Our ref: Waste Management Facility, Botany (SSD-62855708)

Subject: Request for Additional Information

I refer to the Submissions Report for the Waste Management Facility, Botany, State significant development (SSD) application (SSD-62855708). The Department of Planning, Housing and Infrastructure (Department) is reviewing the Submissions Report in consultation with relevant government stakeholders, including Bayside Council (Council). Advice received from government authorities has been forwarded to you for consideration and response.

The Department has reviewed the Submissions Report and requests the following matters regarding the assessment of traffic impacts be addressed as part of a consolidated response to the matters raised by the government authorities. These comments relate to the Traffic Impact Assessment prepared by Traffix dated 20 March 2025, Version 14, submitted as Appendix C to the Submissions Report.

Notes:

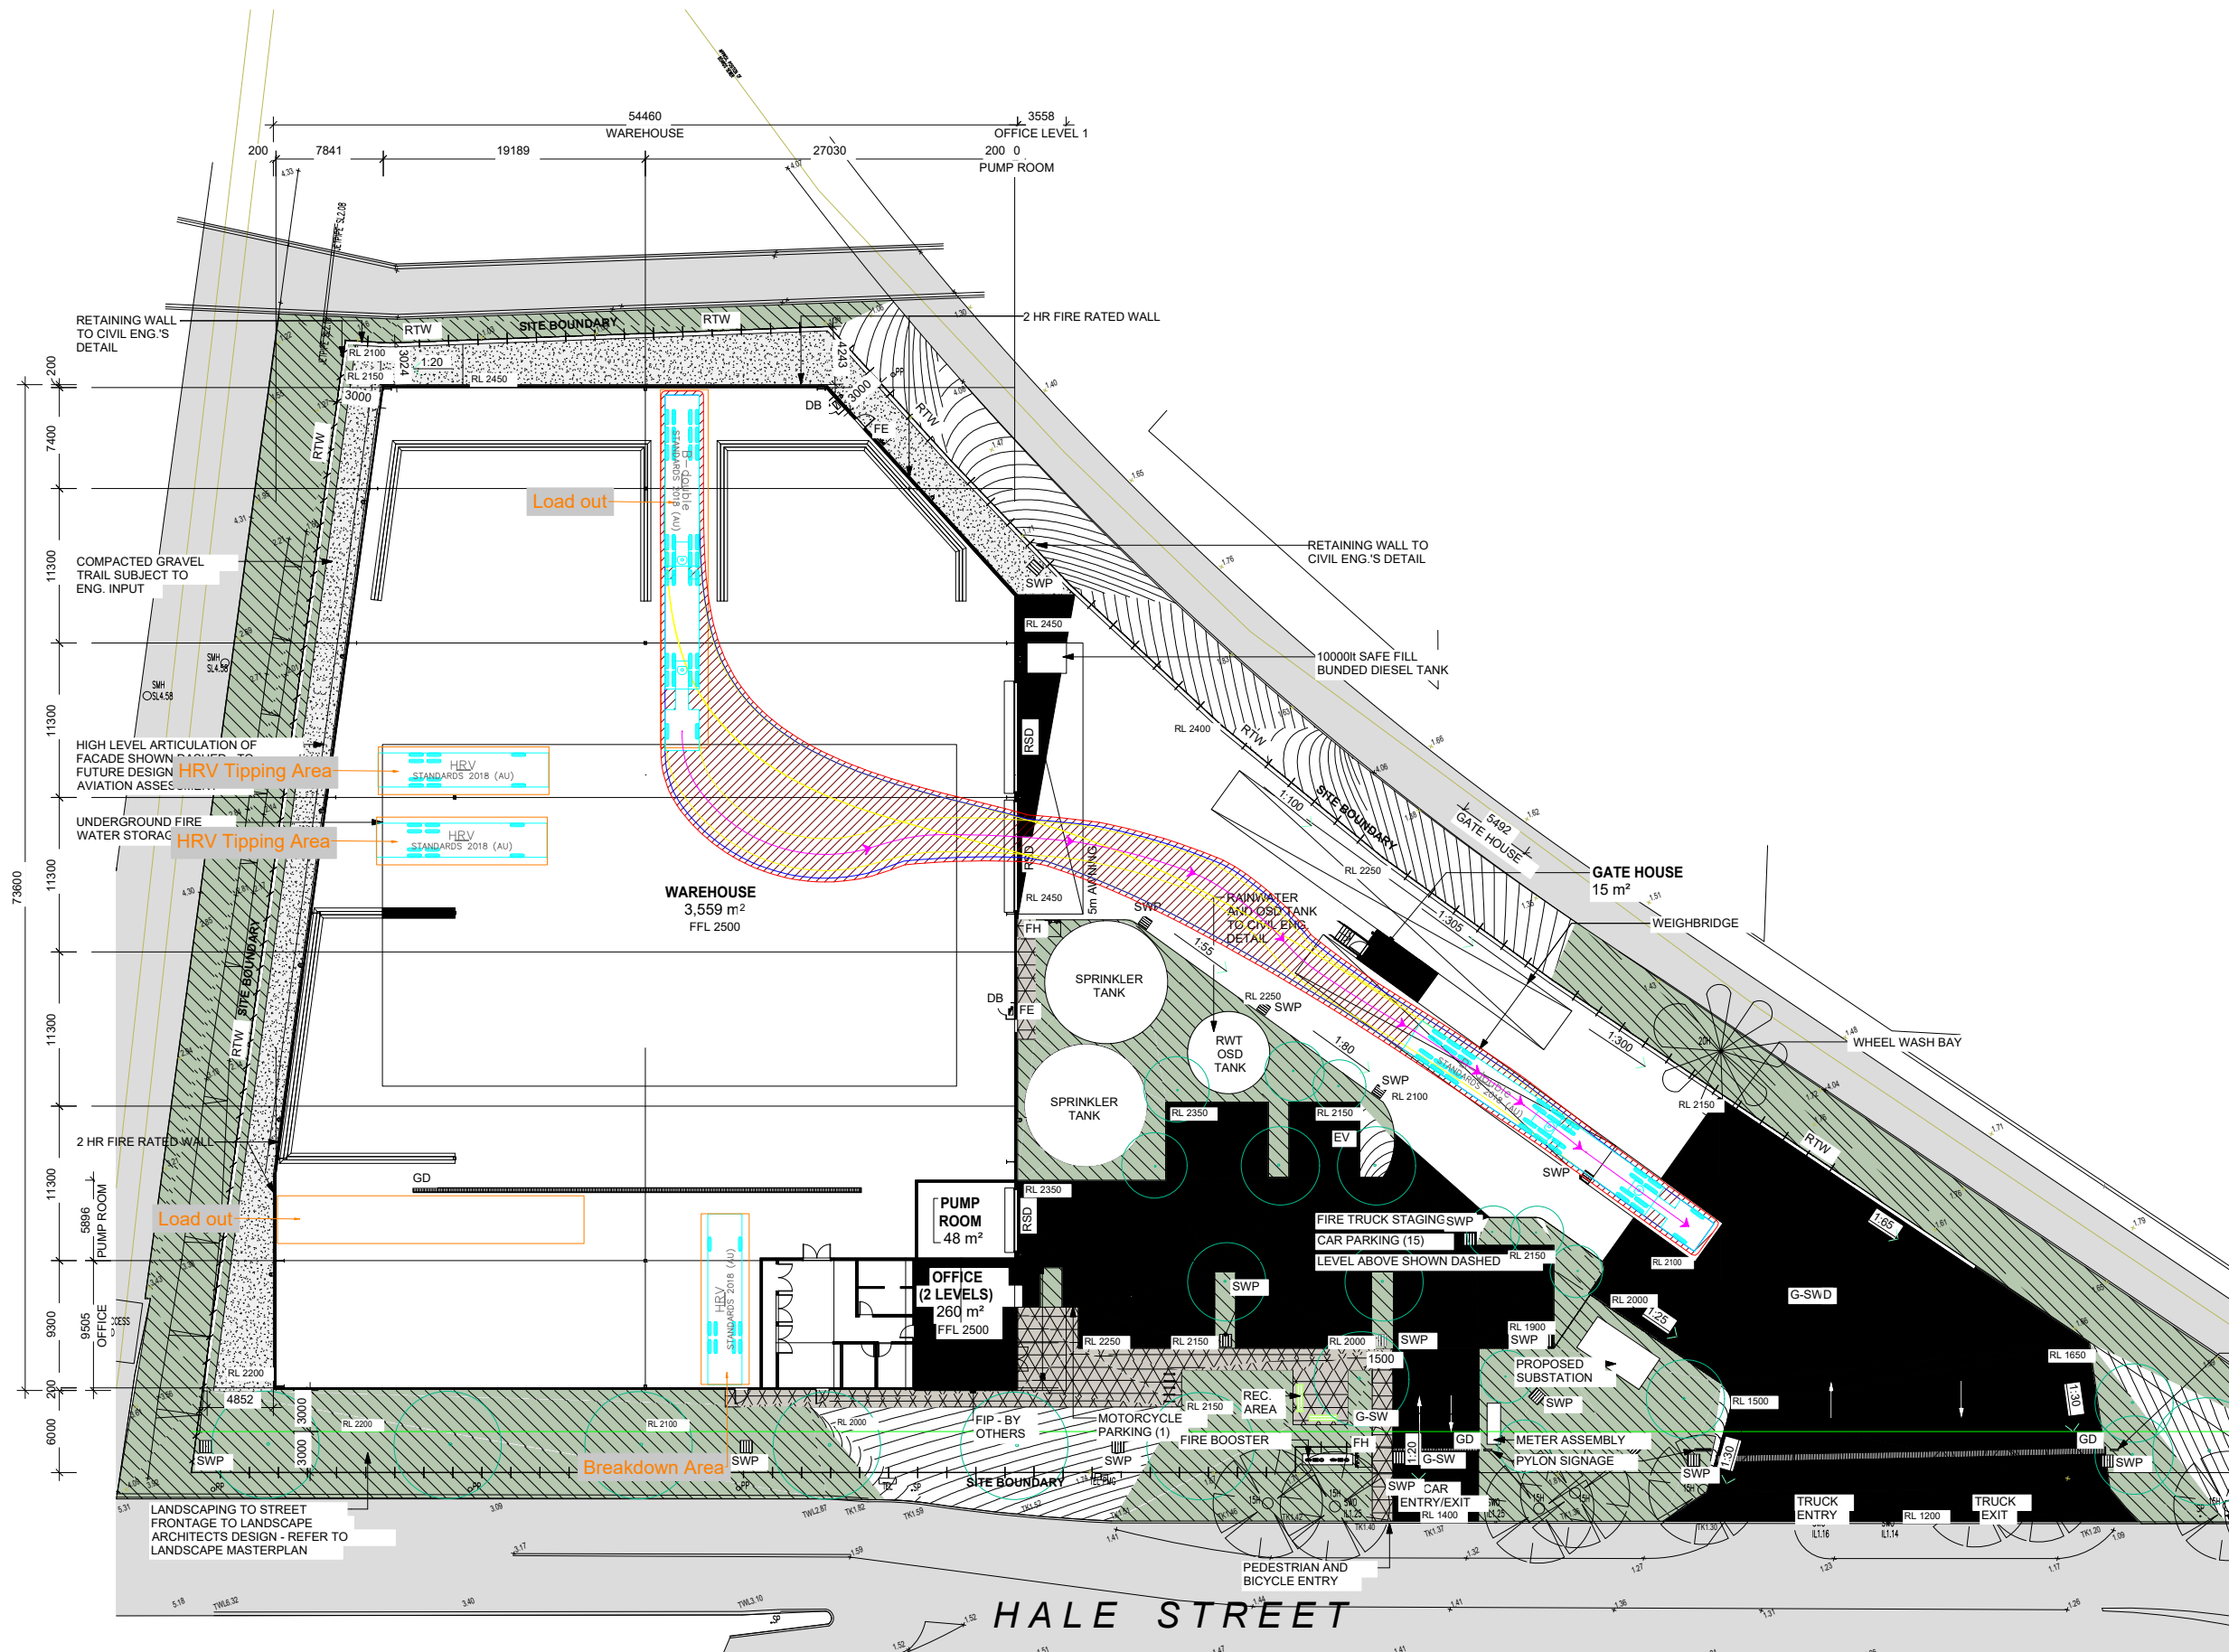
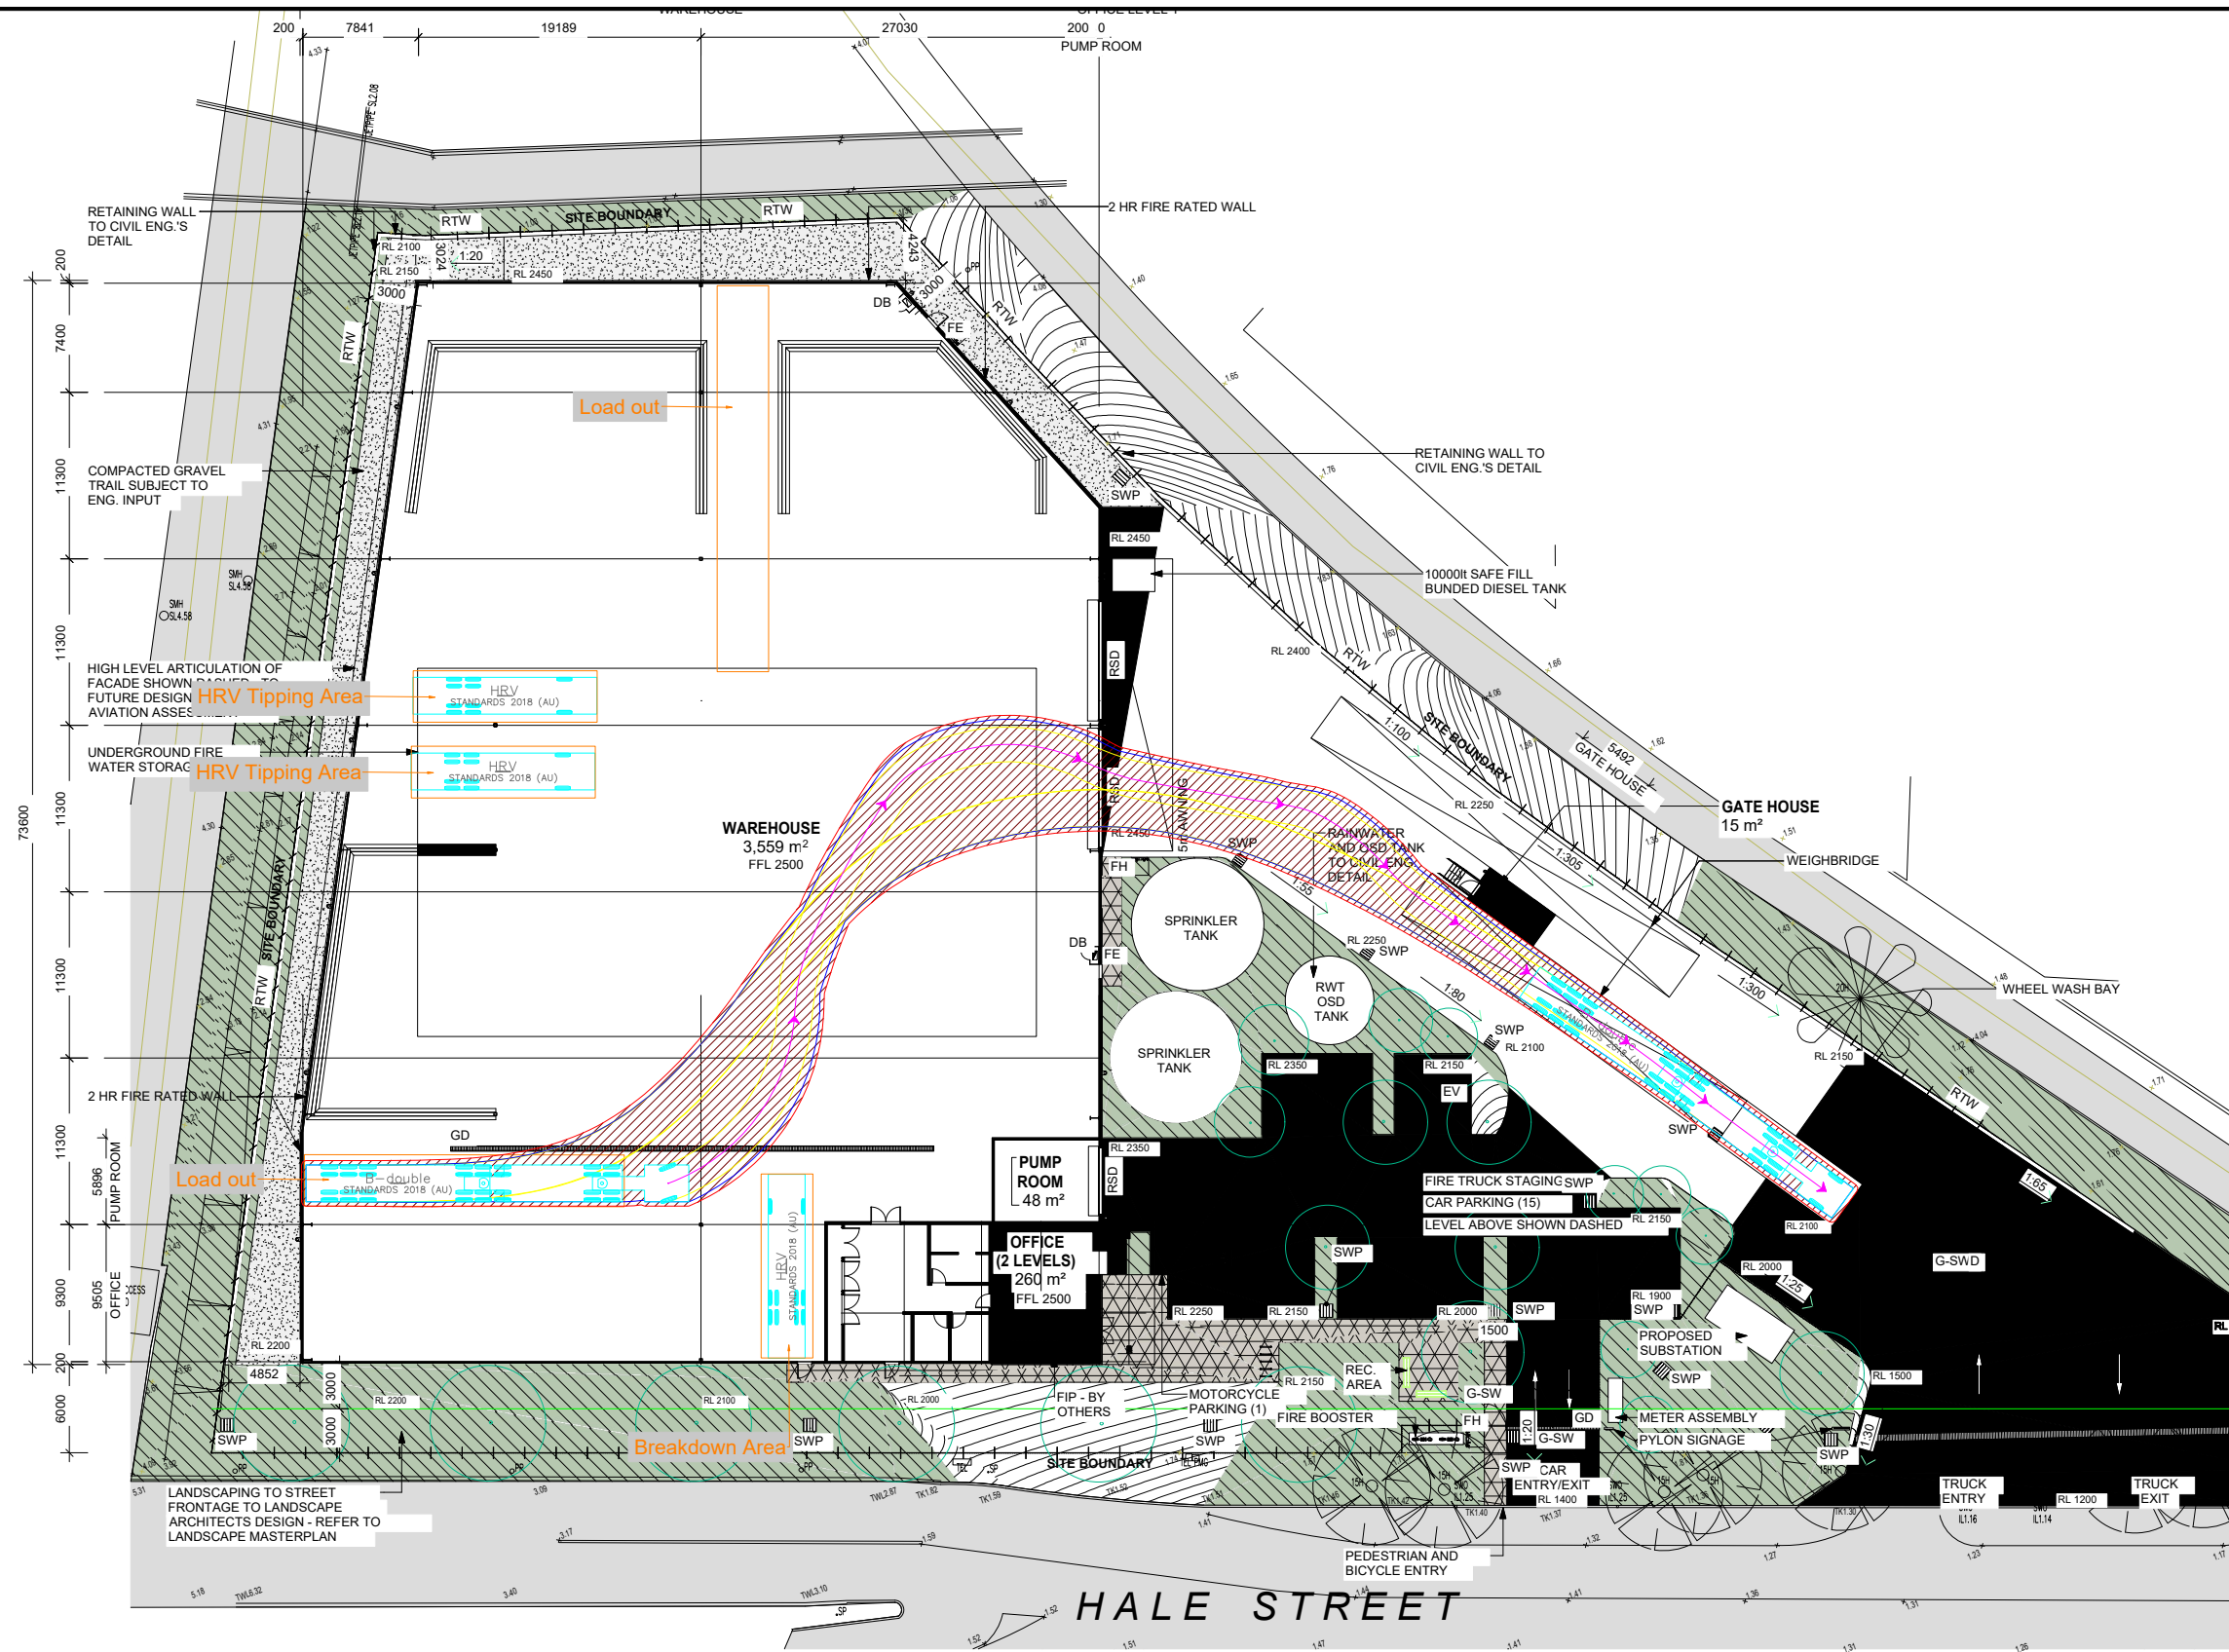
- The swept path analysis shows the movement of a B-double exiting the site on a separate drawing to the swept path of a B-double accessing the site. It is not possible to determine if there will be any conflicts if these two movements occur simultaneously. Please provide a plan that shows a B-double entering and exiting the site simultaneously demonstrating that this movement can occur safely and without any conflict to either vehicle or on-street parking, and without crossing the centreline of Hale Street.
